## Appeal Decision

**Appeal Ref: APP/R4408/W/19/3228246**

**Broom Croft, 11 Stainborough Lane, Hood Green, Barnsley S75 3EZ**

- The appeal is made under section 78 of the Town and Country Planning Act 1990 against a refusal to grant planning permission.
  - The appeal is made by Mr and Mrs Herbert against the decision of Barnsley Metropolitan Borough Council.
  - The application Ref 2018/1328, dated 10 October 2018, was refused by notice dated 8 February 2019.
  - The development proposed is construction of a detached two bed dormer style bungalow with drive.
-

TITLE
DRAWING SHOWING SITE LAYOUT WITH POSITION
OF NEW BUNGALOW

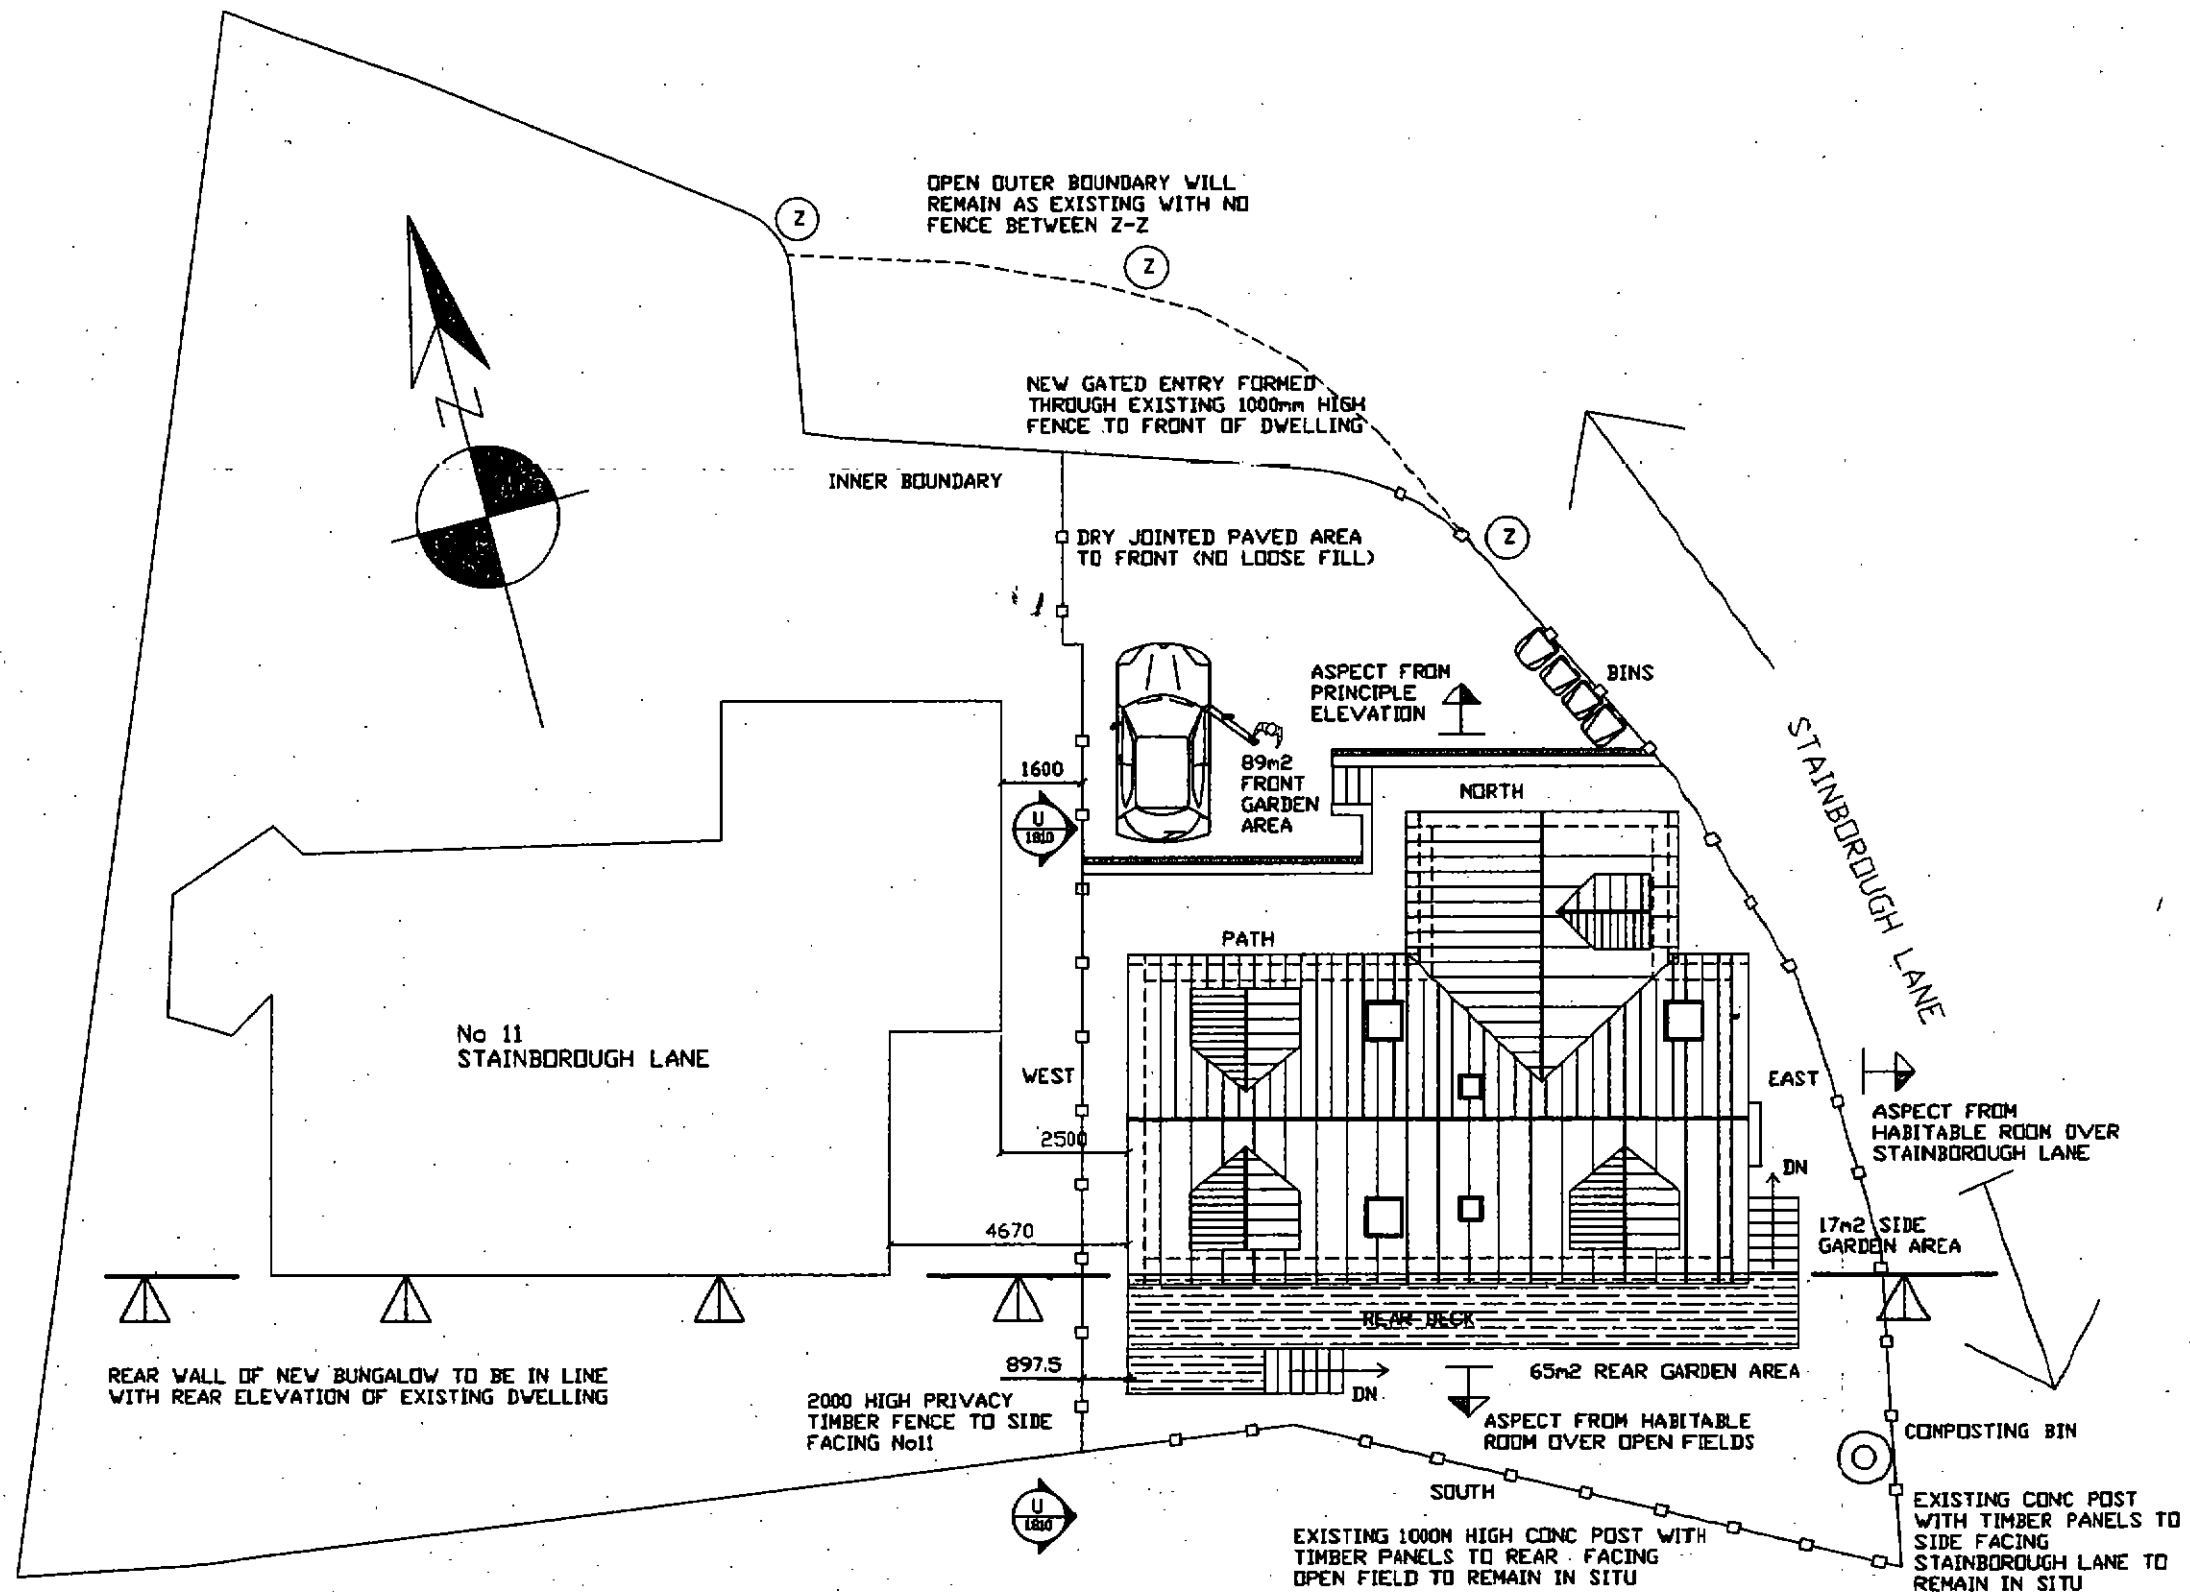
5. The plot formed by the proposed development would be significantly smaller than the surrounding properties on Stainborough Lane and Castle Drive. It would be substantially filled by built development, comprising a parking area and retaining wall to the front and a dormer bungalow with a raised deck at the rear. Very little space would remain between the gable ends of the dormer bungalow and the boundaries of the site. At its north eastern corner the building would be

around 0.5 metre (m) from the boundary with Stainborough Lane. On its western side, the flank wall would be less than 1m from the boundary with Broom Croft. At the rear, although adequate garden space could be achieved to meet the standard of 50 square metres (sqm) in the Design of Housing Development Supplementary Planning Document (SPD) (2019), the alignment of the rear boundary is such that the raised decking would be less than 1m from the edge of site at its nearest point.

6. Although Broom Croft and dwellings on Castle Drive also extend across the width of their plots, generally there are large gaps between buildings at first floor level created by single storey garages and extensions to the side. However, the minimal distance of the proposed dwelling from the boundary with Broom Croft would result in a relatively narrow gap between adjacent buildings at first floor level. Overall the restricted plot size, the proximity of the proposed dwelling to the boundaries of the site and the lack of space around it would create a cramped form of development, out of keeping with the spacious character of the surrounding properties.

TITLE
DRAWING SHOWING PROPOSED ELEVATIONS OF
NEW DORMER BUNGALOW

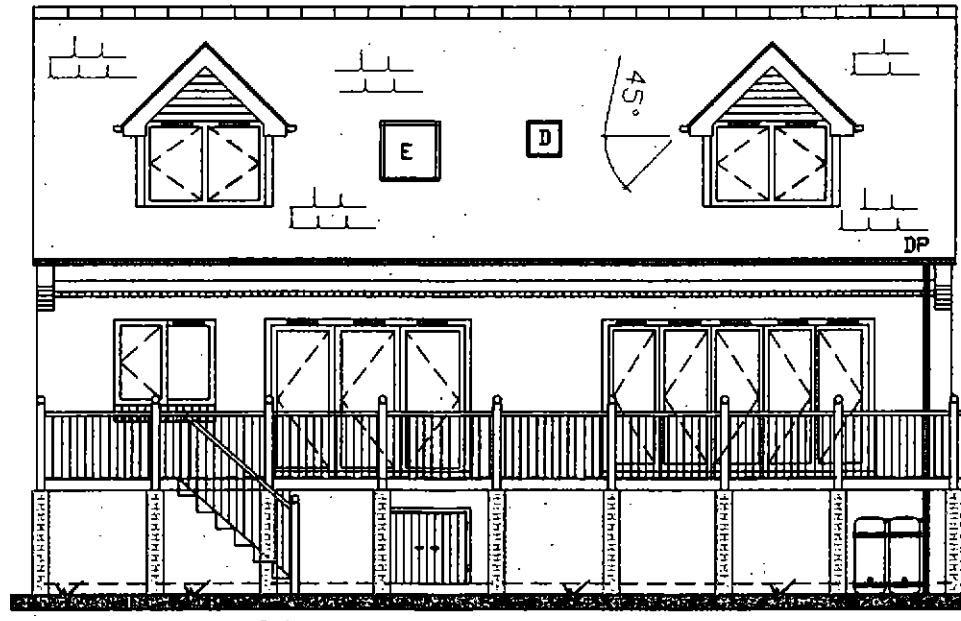
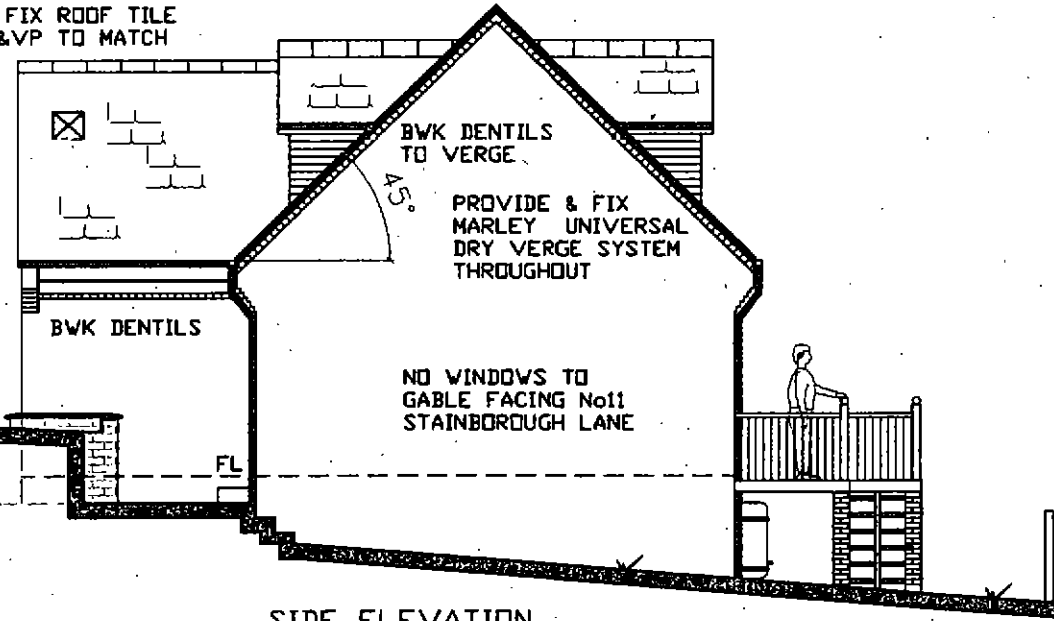
7. The site also falls from north to south and west to east towards Stainborough Lane. The proposed dwelling has been designed to reflect the overall height, floor level and scale of Broom Croft. However, due to the gradient of the site, its finished floor level would be around 2m above the ground level on the south-eastern corner of the building. Much of its eastern flank gable wall would be visible above the height of the fence on Stainborough Lane, within just 0.5-2.5m of the boundary, leaving little room to plant trees large enough to screen the building. As a result, viewed from Stainborough Lane approaching the edge of the village, the proposed dormer bungalow would appear as a dominant and visually intrusive urban form within what is currently an open and maturely landscaped street scene at this entrance to Hood Green.
